Engineers Comments Regarding Surface Water Drainage

Application Reference:	P/107/25/DOC	Reviewer Reference:	ADC/EXT4
Planning Officer:	Jessica Riches	Date of Review:	12/12/2025
Site Name:	Land West of Hook Lane Pagham PO21 3PB		
Application Description:	Approval of details reserved by condition imposed under P/149/23/S73 relating to condition 9 c) surface water drainage.		
Assessment Number:	3 of 3

Application Reference: P/107/25/DOC Site Name: Land West of Hook Lane Pagham PO21 3PB	Initial Issue Date: 12/12/2025 Issue Date: 12/12/2025 Reviewer Reference: ADC/EXT4
--	--

TYPICAL SECTION ALONG ATTENUATION SYSTEM (REFER TO DRAWING C016)

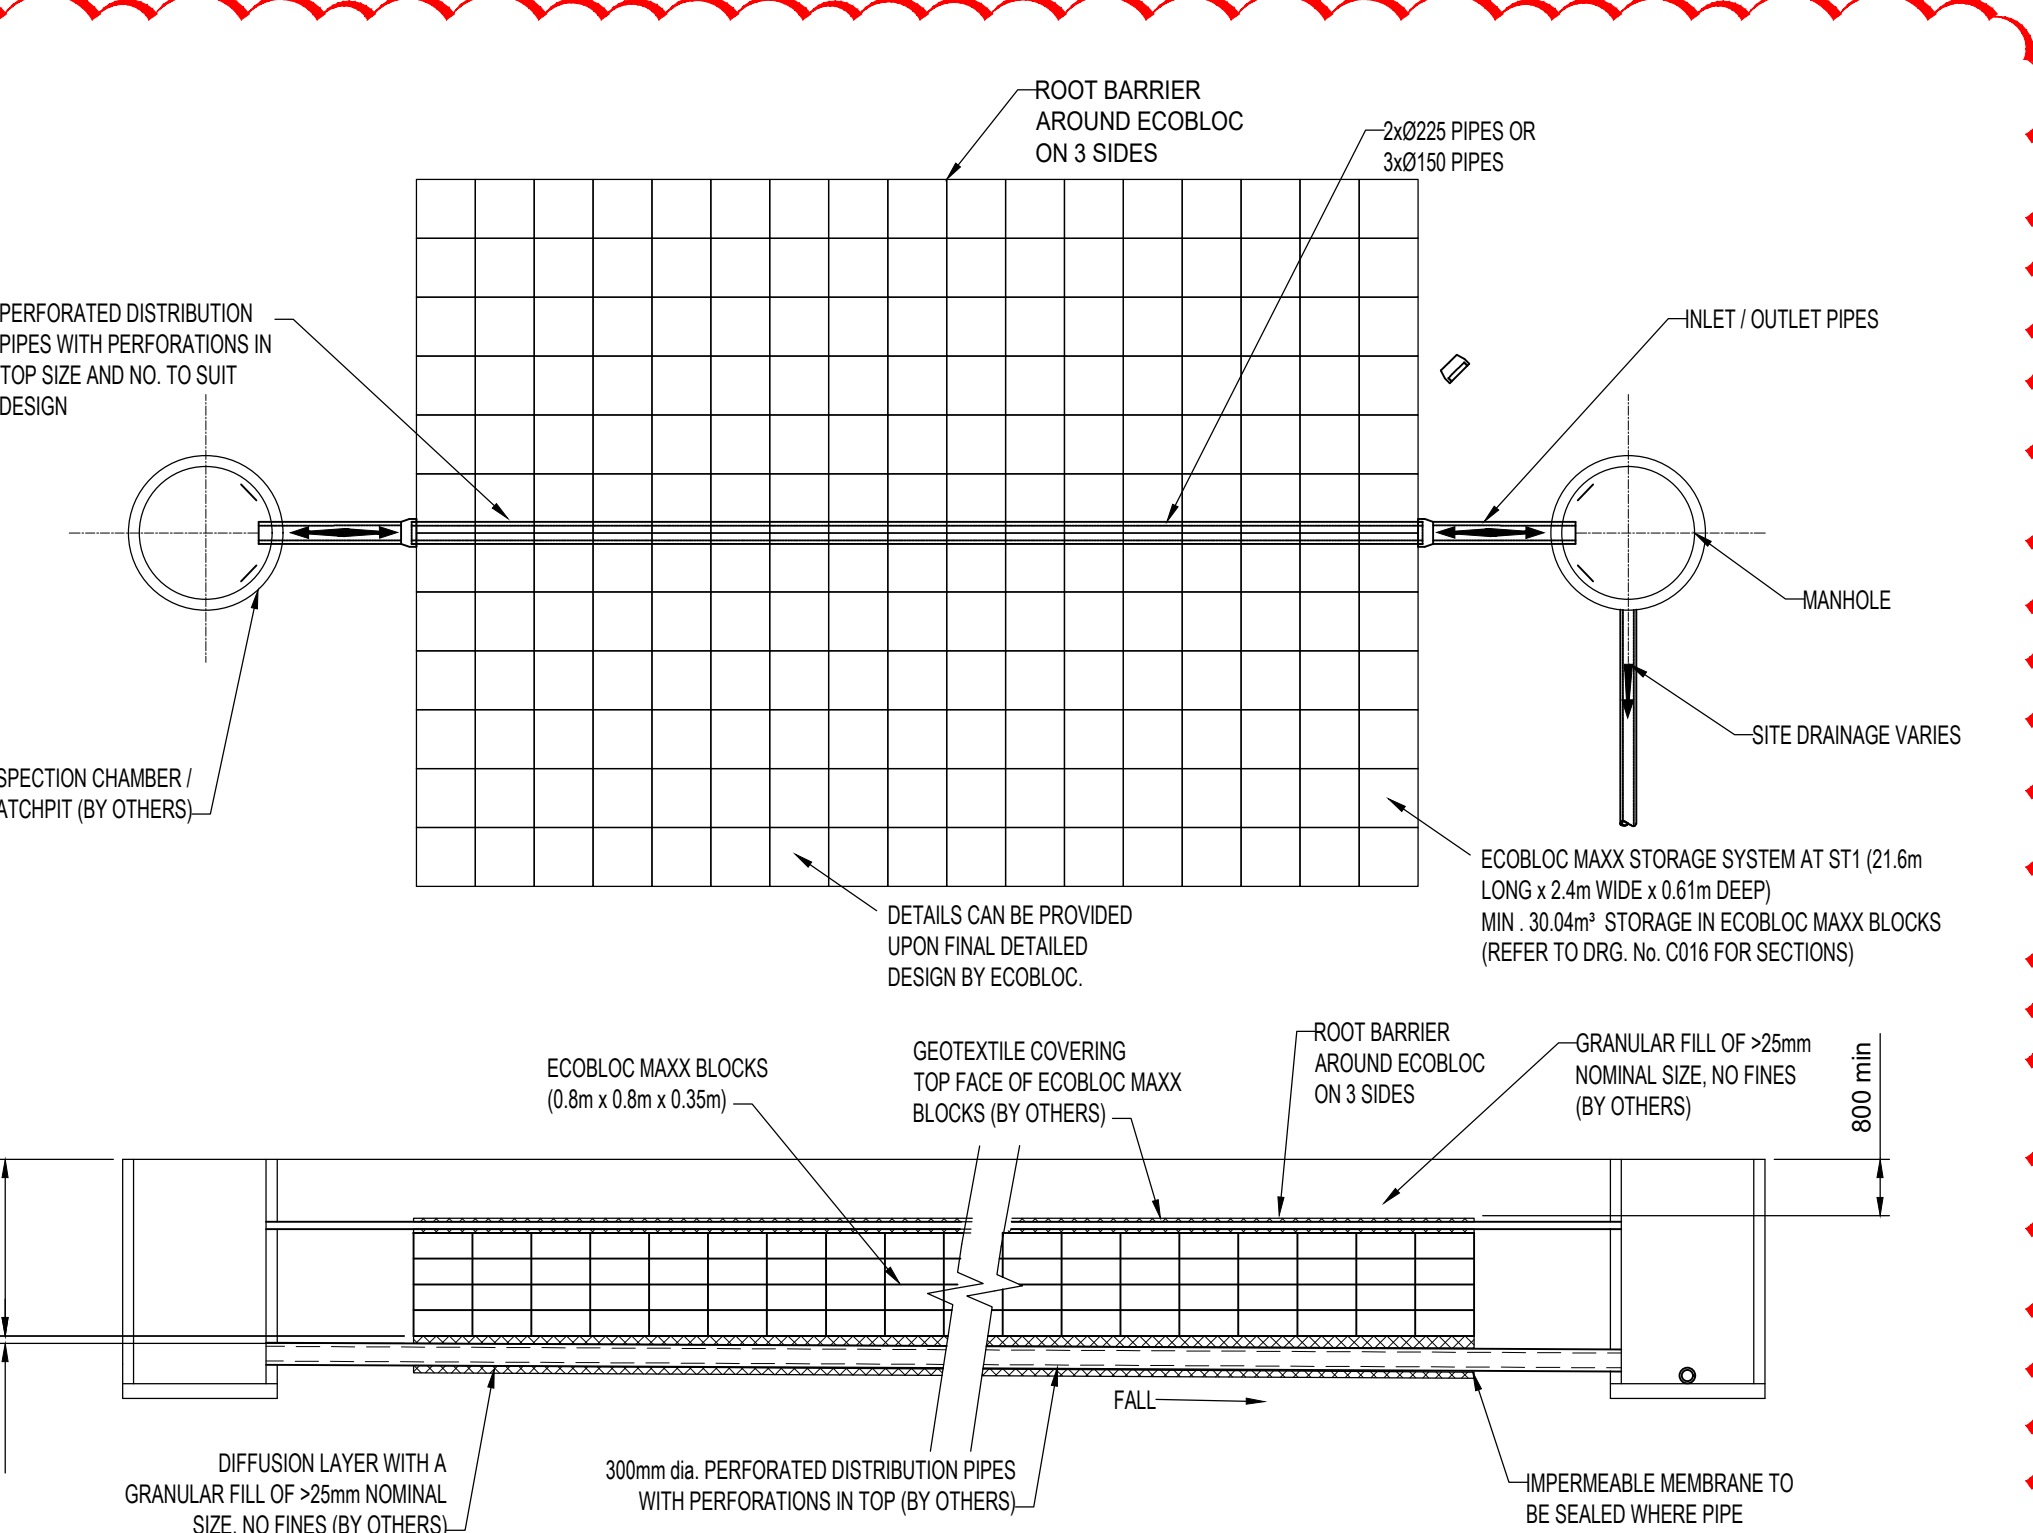
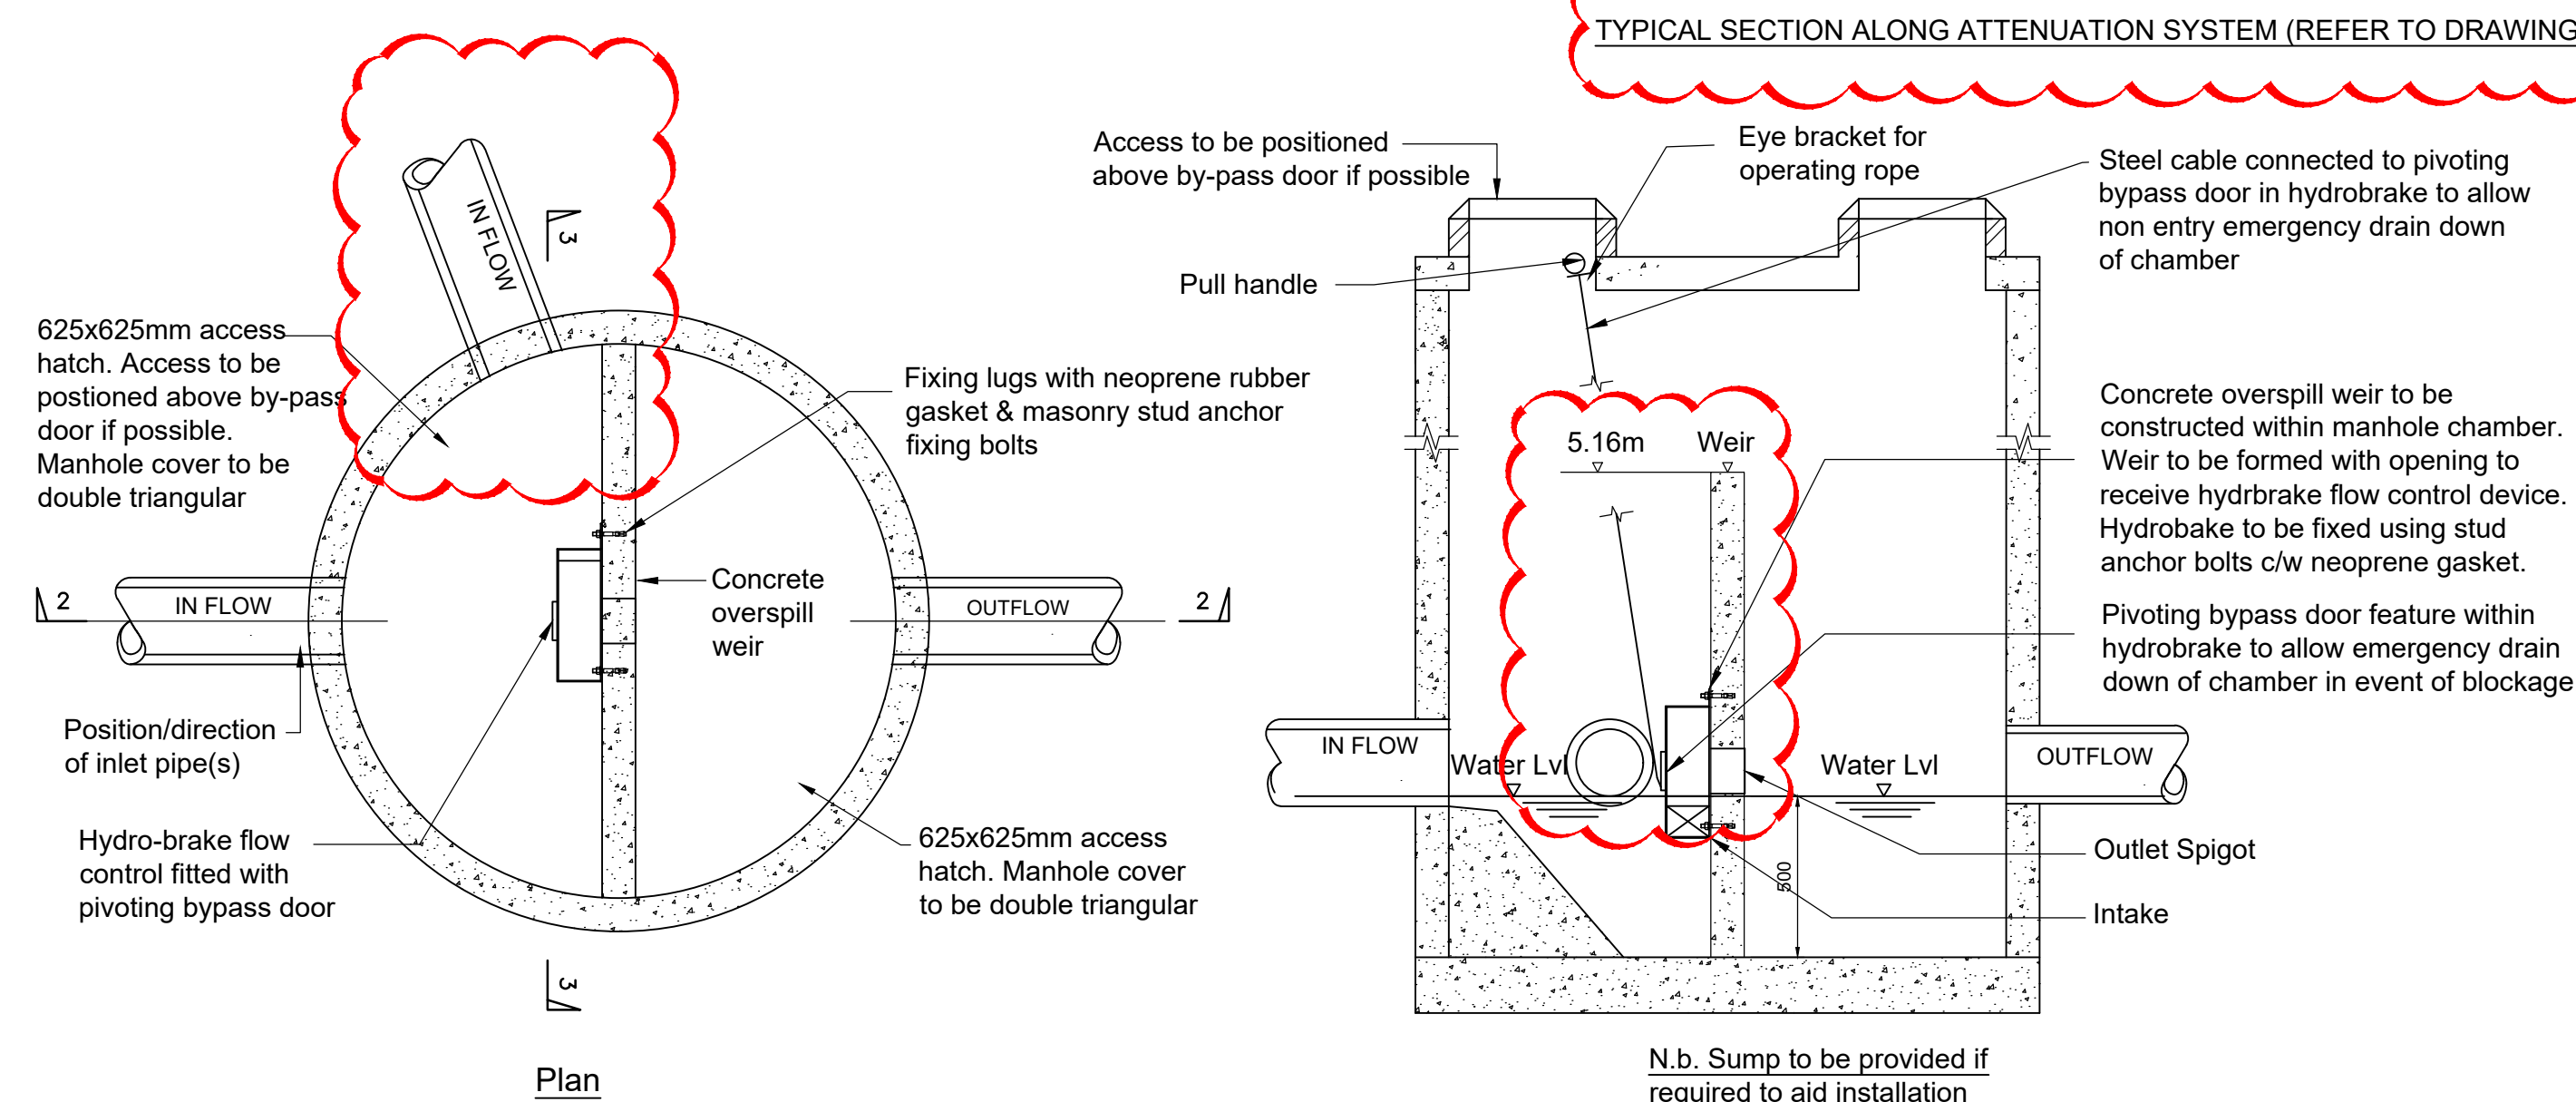
to the upstream and downstream chambers, no details are provided showing how these chambers are vented e) The tank detail suggest that pipes run through it at base level, this is not shown on the plan f) The tank detail refers to Ecobloc and Stormcell, the plan refers to Aco Stormbrix. g) The tank detail does not state which specific product in the range it to be used. eg. There are 3 types of Stormbrixx h) The tank detail specifies a plan size that is not consistent with the drainage plan i) The tank detail makes reference to “final detailed design by Ecobloc. Provide the final design j) The permeable paving detail shows a 150mm perforated pipe, the	F. Rev. C calculations. GRAF ECO block MAXX clearly shown. Updated Drawings & Calculations. G. Updated Drawings & Calculations. H. Rev. C Calculations. Updated Drawings & Calculations. I. We have removed this note. This should be forwarded later after PLANNING. J. No impact. Updated Drawings & Calculations. K. Rev. C Calculations - Updated Drawings & Calculations. L. As shown on details – steel cable connected to pivoting bypass door for blockages as shown on C003 drawing.	comment to A F. Item now closed G. Item now closed H. Item now closed I. The detailed design of these tanks are required to support this condition J. Item now closed K. Item now closed L. Item now closed M. item now closed N. Item now closed O. Item now closed P. P. Item now closed	See Appendix H for detailed Graf Drawings.	I. Item now closed

GRAF ECOBLOC MAXX STORAGE SYSTEM (ST1)
(21.6x2.4x0.61m - 30.04m³)

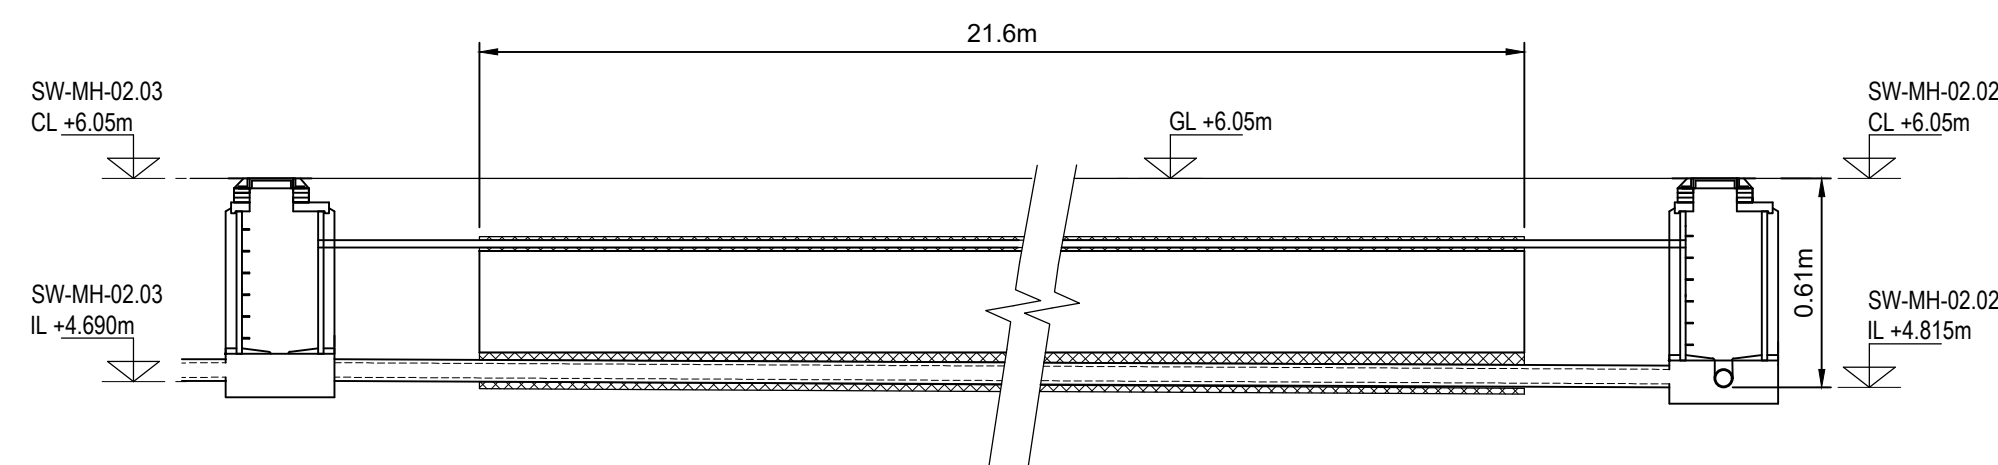
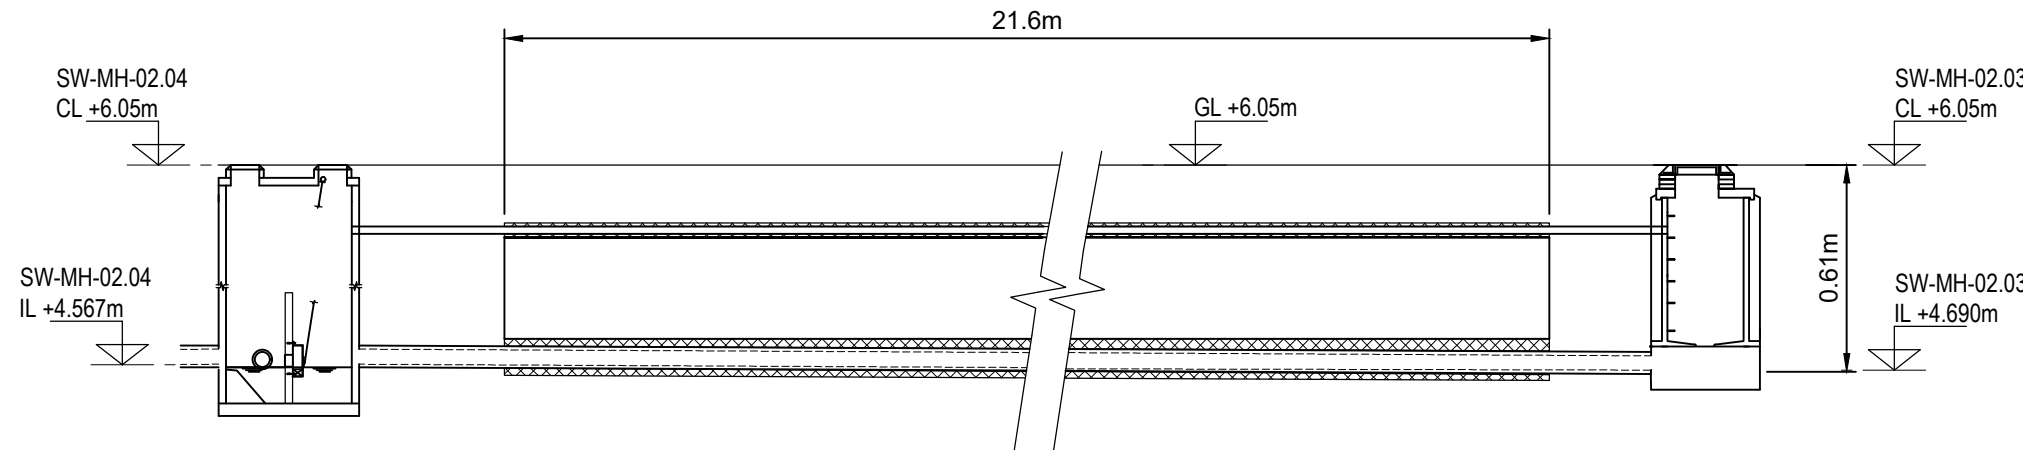
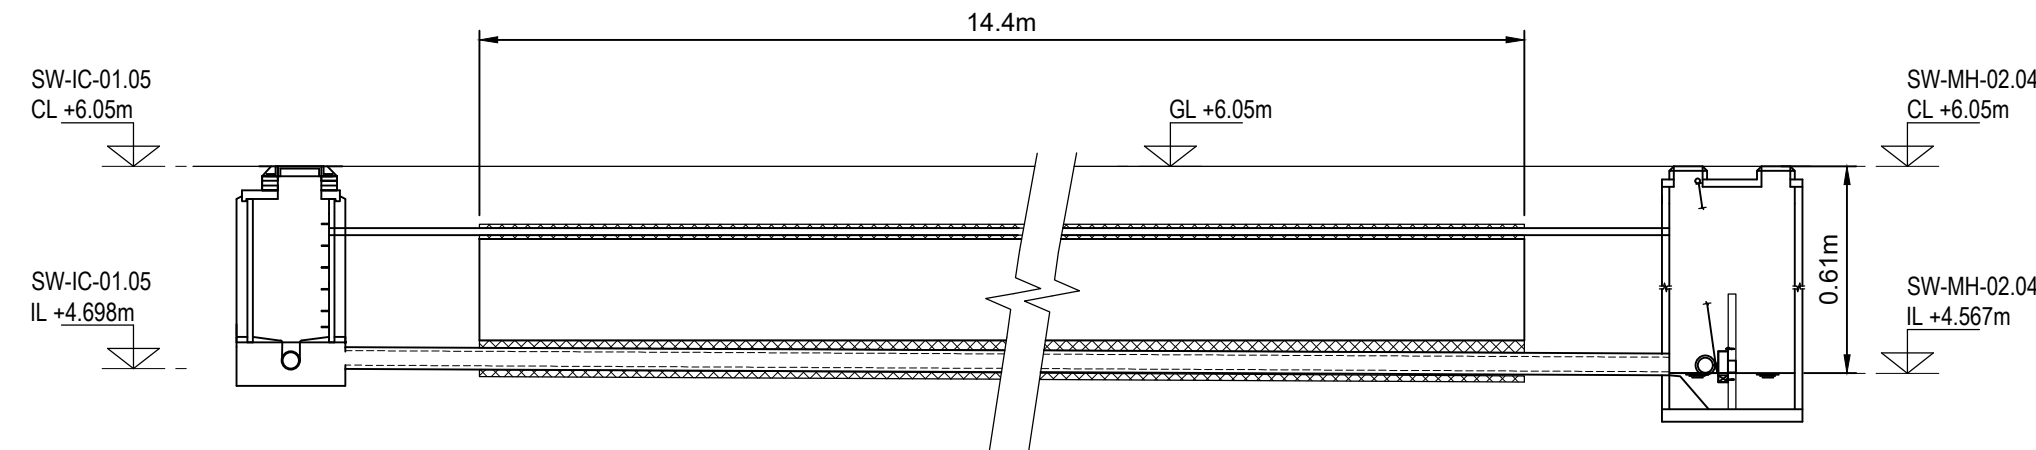
e) Tank SW1 appears to be oversized in the calculations. The drawing states 21.6x3.6=77.76m². The calculations use an area of 82.1m² f) Calculations use a design head of 1.5m for the flow control, 1m is stated on the drainage plan g) The final connection is shown as 150mm dia on the drainage plan but 300mm dia in the calculations. It is shown with a gradient of 1:200. Demonstrate that this will be self cleansing with the proposed 2l/s flow rate. h) The calculations do not confirm pipe gradients or lengths i) The calculations do not include invert levels but a check using the chamber depth shows that that invert levels in the calculations are not consistent with the drawings.	G. Responded in previous Rev. C calculations. Updated Drawings & Calculations. H. These details are ALL in the Rev. C calculations. Pg25-28 including other sections. Updated Drawings & Calculations. I. These details are ALL in the Rev. C calculations. Pg25-28 including other sections. Updated Drawings & Calculations. J. Replied in Rev. C calculations. Updated Drawings & Calculations. K. These details were included in Rev. C calculations. Updated Drawings & Calculations
